Re: Proposed flood relief scheme
in Mountmellick, County Laois

15 December 2025

Case Reference: JA11.323830
Re: Mountmellick Flood Relief Scheme, Co. Laois
Submitted via email to: laps@pleanala.ie

Figure 2-2: Study area; FRS defences and local watercourses (OSM, 2023)

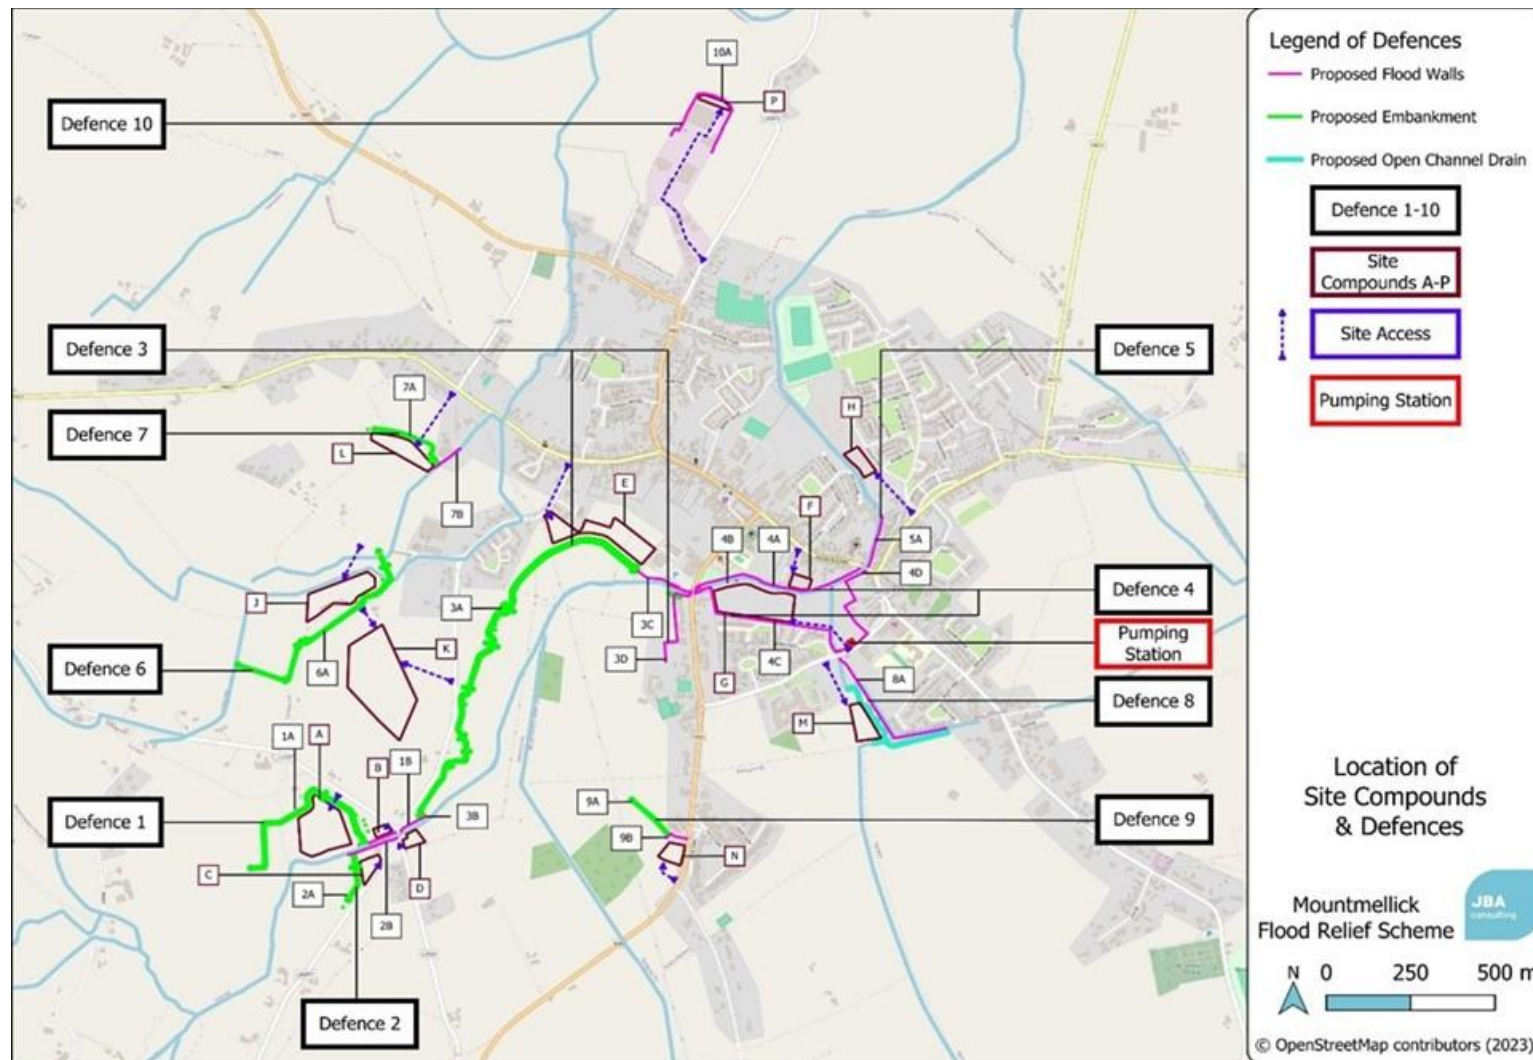
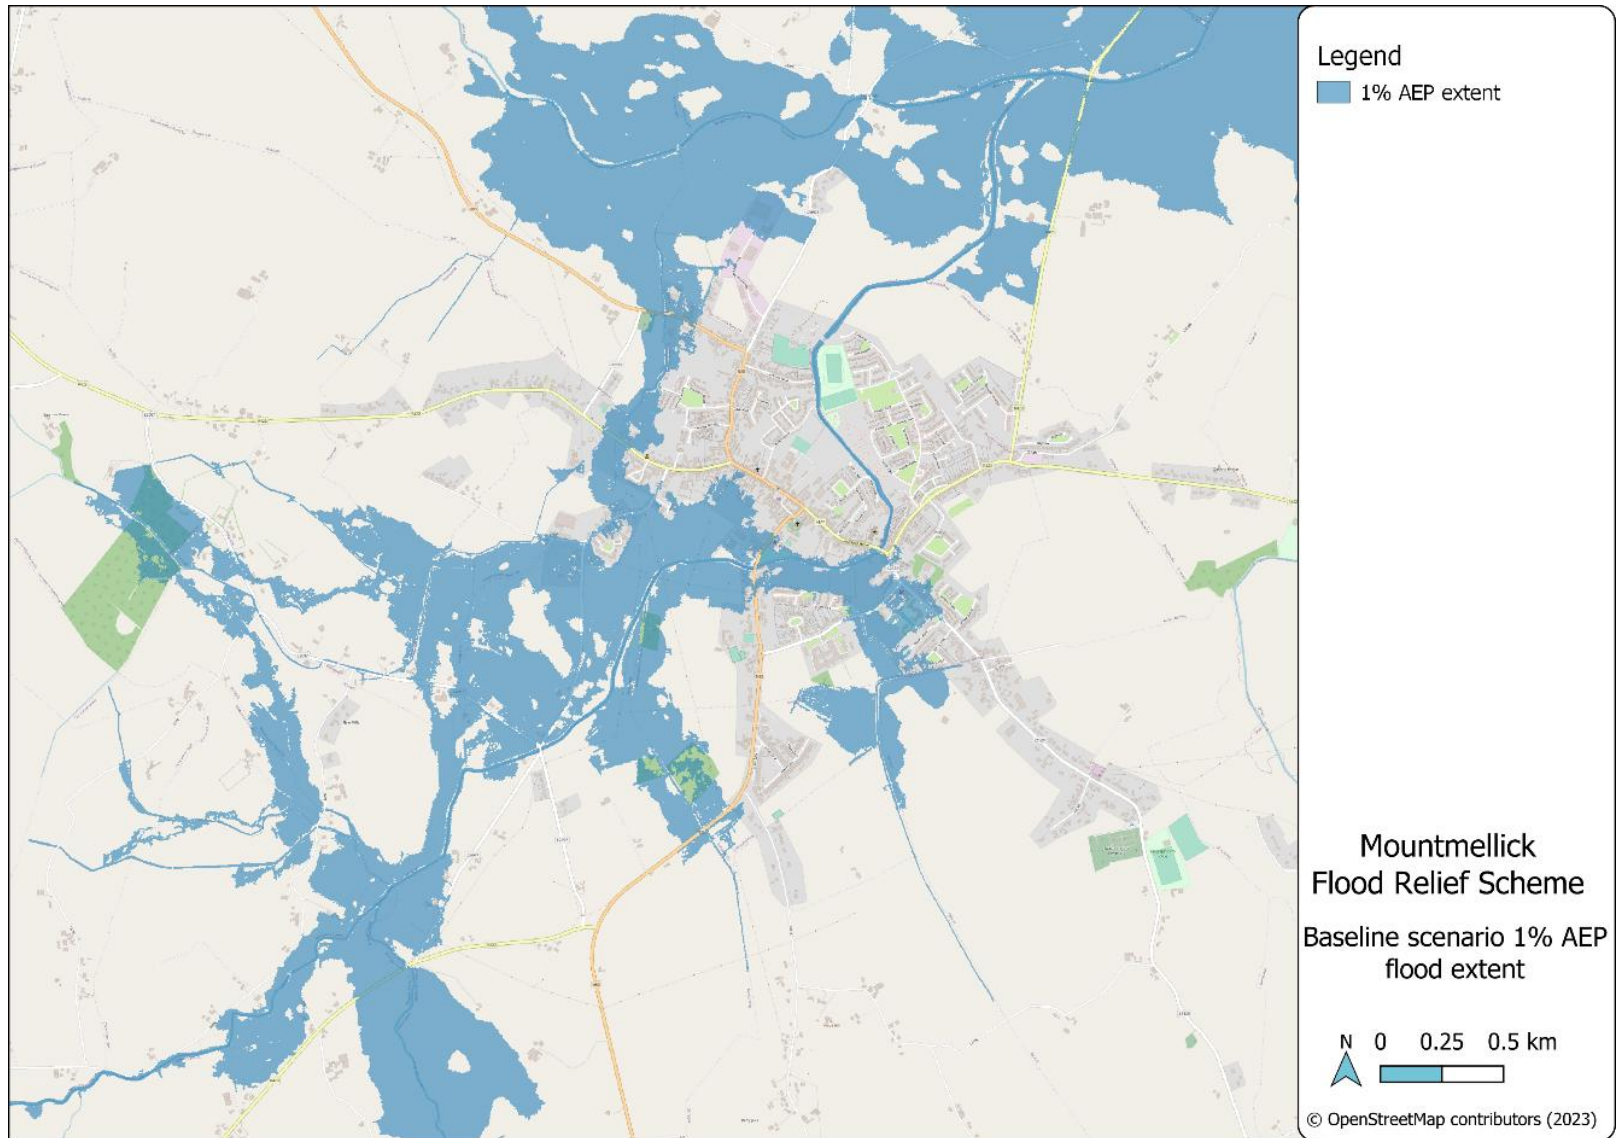
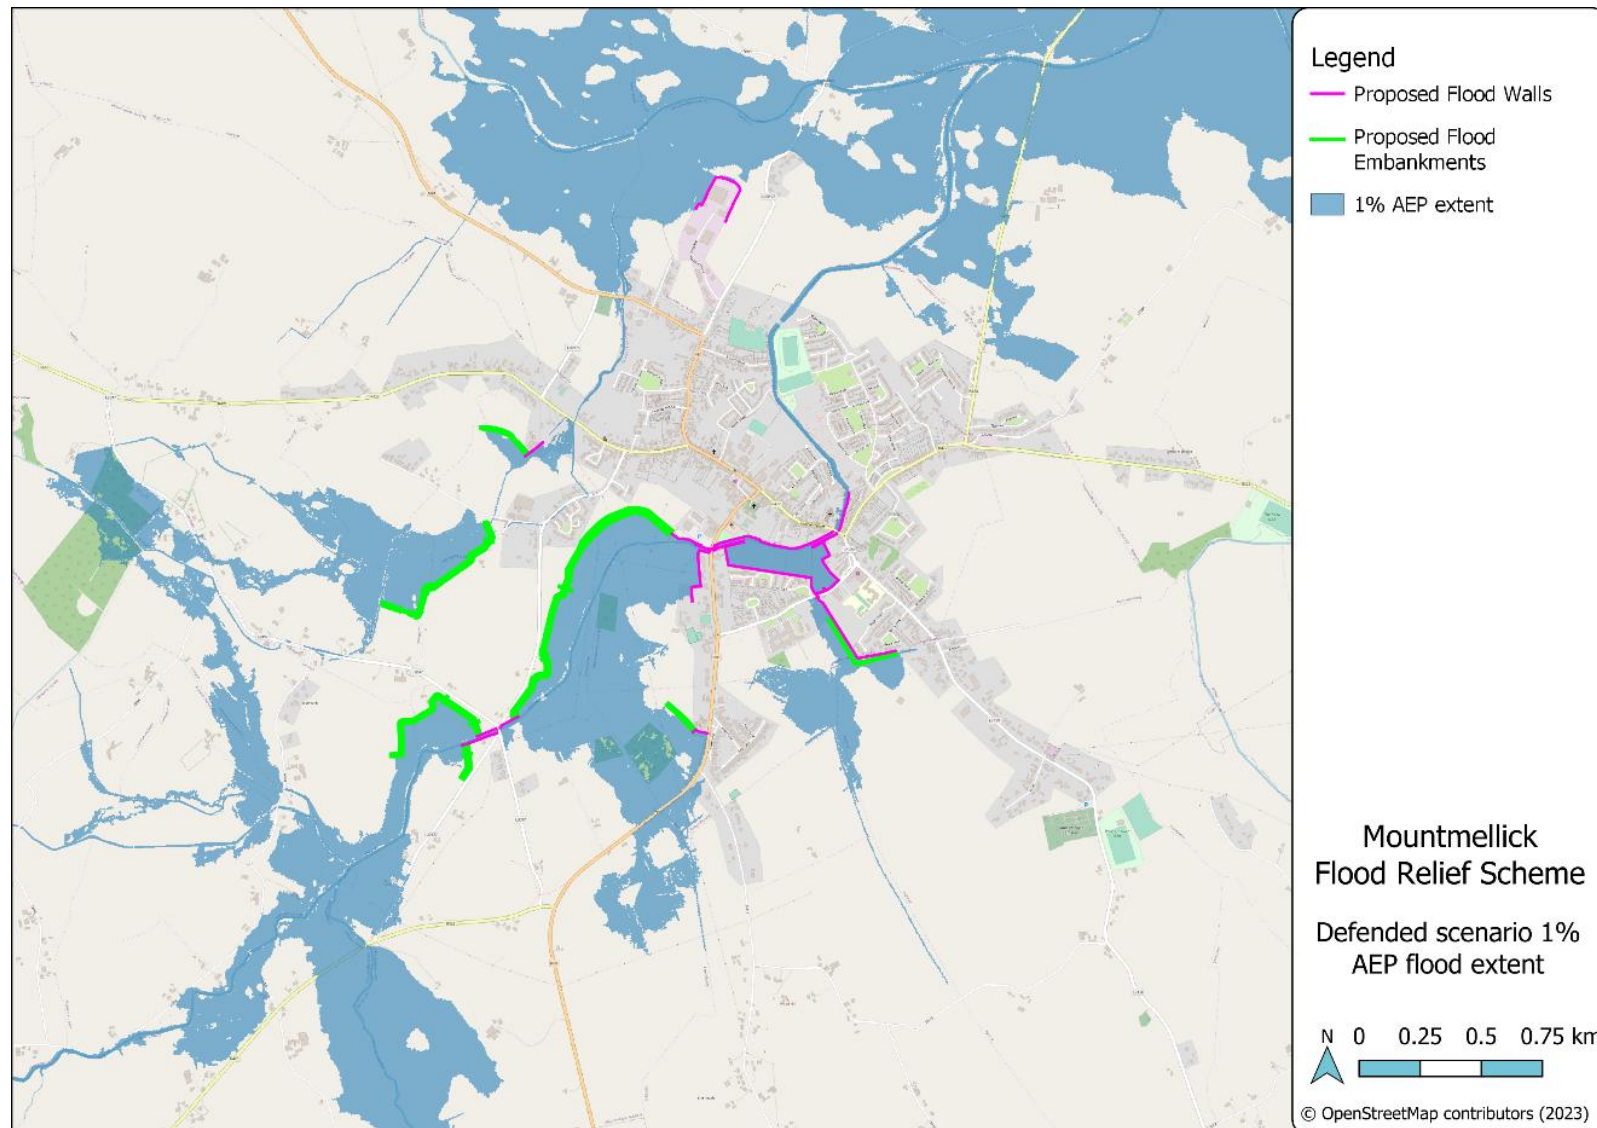
IFI Comment – At a meeting with JBA Consultants on 6 March 2024, JBA provided a commitment to IFI that the wall would be located at least 5m from the top of the bank of the river, on the landward side of the treeline. This was confirmed by IFI in subsequent correspondence to JBA dated 27 March 2024. IFI requests that this commitment is included as a condition of planning. Regarding the proposed vegetation removal, see General Condition No. 9 below.

IFI Comment – At the meeting on 6 March 2024, JBA committed to locating the wall along the line of the existing fence at the top of the bank of the river. IFI confirmed this in subsequent correspondence dated 27 March 2024. IFI requests that this commitment is included as a condition of planning. Regarding the proposed vegetation removal, see General Condition No. 9 below.

IFI Comment – Section 4.3.3 of the EIA Report and Section 2.4.3 of the AA Screening suggest that instream sheet piling will be used at this location, whereas Table 2-1 of the AA Screening states the wall will be set back from the river. As stated above, the area downstream of Owenass Bridge is an important spawning habitat for salmonids. At IFI's meeting with JBA on 6 March 2024, JBA informed IFI that the wall at 3B was to be set back from river by 5-10m. IFI request that the plans are amended to reflect this and that this is included as a condition of planning for the works. Regarding the proposed vegetation removal, see General Condition No. 9 below.

IFI Comment – The applicant's plans state that 5m of this wall be situated instream. No instream works were agreed with IFI at this site. IFI request that the plans are amended to reflect discussions and subsequent correspondence with the consultants in March 2024.

IFI Comment – IFI request that the wall will be set back a minimum of 5m from the river at its downstream end, as agreed on 6 March 2024 and confirmed via subsequent correspondence on 27 March.

IFI Comment – The Owenass River between Mill Bridge and Convent Bridge contains salmonid spawning grounds. In its meeting on 6 March 2024, IFI agreed with JBA that the proposed wall 4A would be located along the current line of footpath in playground. Where trees must be felled the stumps will be preserved to maintain bank integrity. Additional planting may take place between the stumps. Further downstream IFI requested that the wall is to be a minimum of 5m from top of bank to Convent Bridge.

IFI Comment – The wall will be set back from the top of the riverbank for the initial 50m. From the ramp the wall will be located on the landward side of path. IFI expressed a preference that this wall does not extend downstream past tie-in with Defence 4C to maximise lateral connectivity with the proposed floodplain to the north of wall 4C.

IFI Comment – Section 4.3.4 of the EIAR states that the applicant's plans propose 20m of instream walls at defence 4D. IFI have not agreed to instream works at this location. IFI request further clarification regarding these proposed works, and that the plans reflect discussions and subsequent correspondence with the consultants which took place in March 2024.

IFI also expressed a preference that the wall 4D does not extend upstream of the tie-in with wall 4C, to maximise lateral connectivity with the proposed floodplain to the north of 4C.

IFI Comment –IFI notes that this is an extremely confined site. It is also a sensitive site from a fisheries perspective, as there is salmonid spawning for c. 100m downstream of Convent Bridge. Section 4.3.5 of the EIAR and 2.4.5 of the AA Screening state that instream defences may be required at this site. No instream works were agreed with IFI however. IFI request that the plans are amended to reflect this.

IFI Comment – IFI request that wall 7B is set back a minimum of 5m from top of bank.

IFI Comment – IFI requests that the proposed wall is set back 5m from the riparian margin along the northern perimeter of the Midland Steel site.
